Rezoning Transportation Analysis

Petition Number: 2023-092

Date	Description
9-28-23	First Review (NK)
11-27-23	Second Review (JP)

REZONING
SITE PLAN
SHEET **C100**

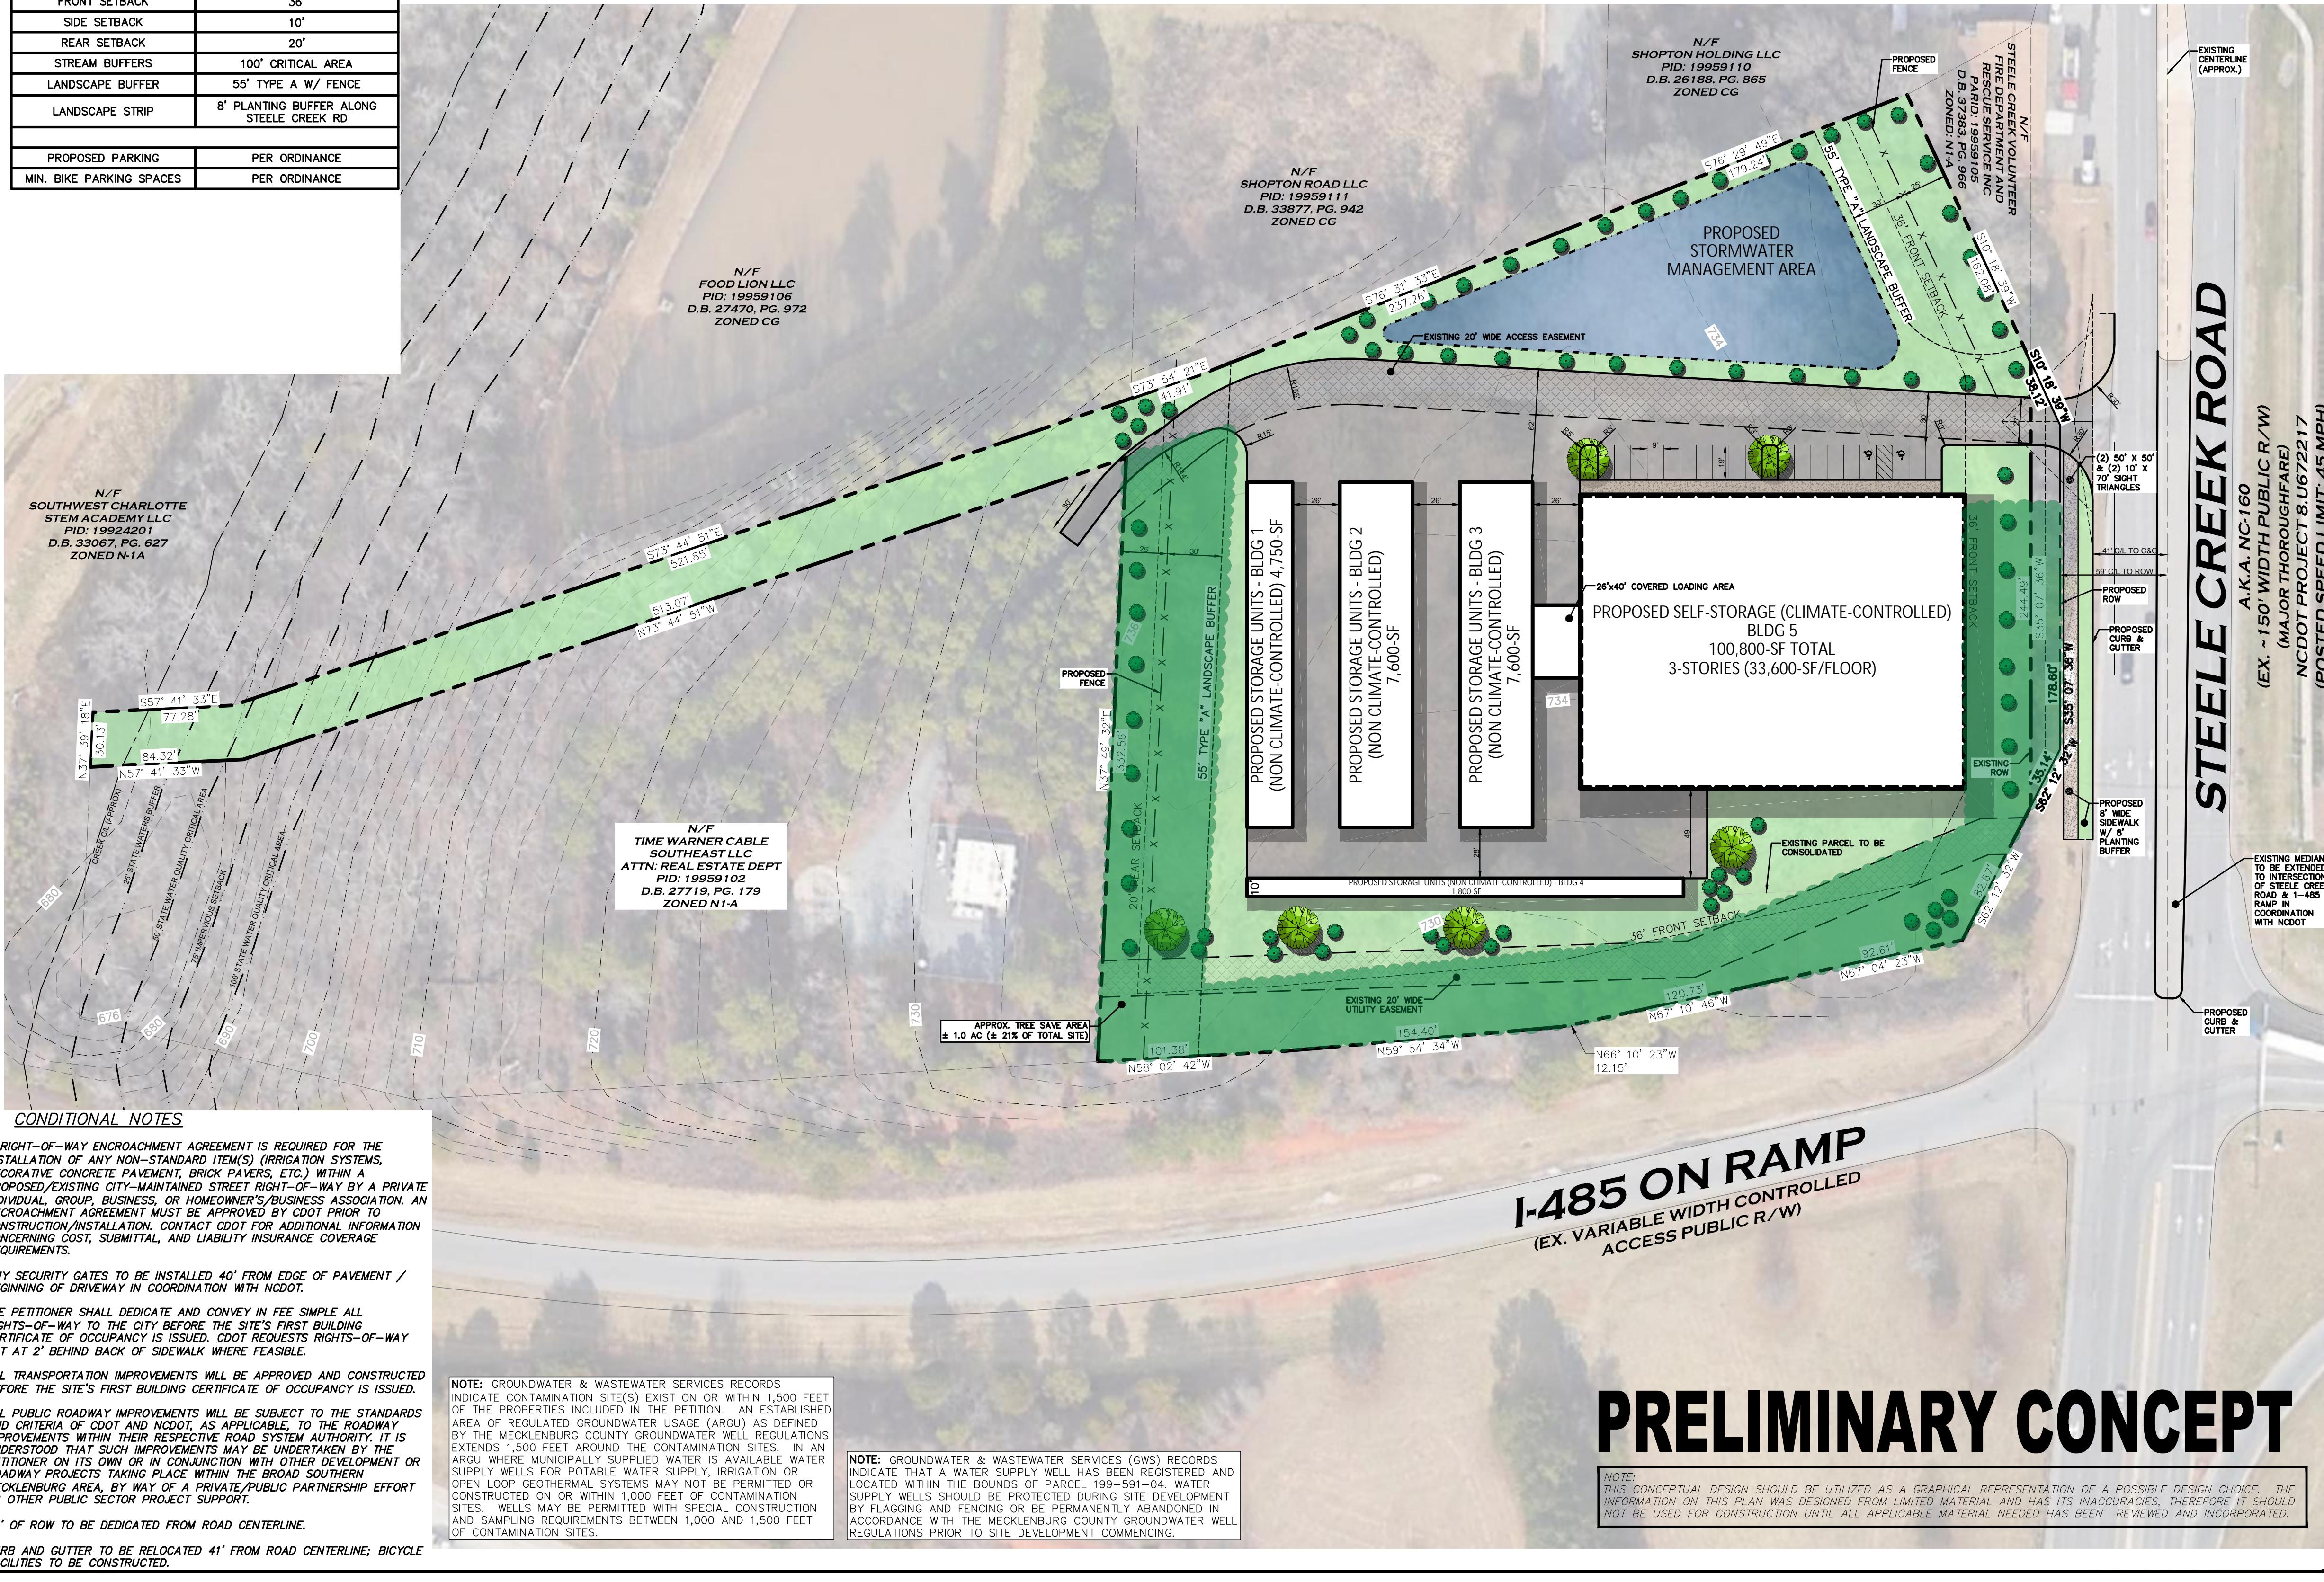
a. ~~**Steele Creek Road:** Location of back of curb and gutter to be moved to 41 feet from roadway centerline to accommodate the Charlotte Streets Map.~~

~~The required cross section is 4+ Boulevard, Buffered/Separated Bike Lanes~~

~~Label and dimension the curb and gutter from the centerline for each road on the site plan.~~

~~3. Revise site plan and conditional note(s) to commit to dedicate 50' right-of-way from the road centerline. The site plan shall label and dimension the right of way from the road centerline.~~

~~4. Revise site plan and conditional note(s) to commit to construct bicycle facilities by locating the curb and gutter 41' from the center line.~~

~~6. Revise site plan to commit to extending the existing median to the intersection of the I-485 ramp and Steele Creek Road in coordination with NCDOT.~~

~~7. Add a conditional note stating that any security gates must be installed 40' from the edge of pavement / beginning of the driveway in coordination with NCDOT.~~
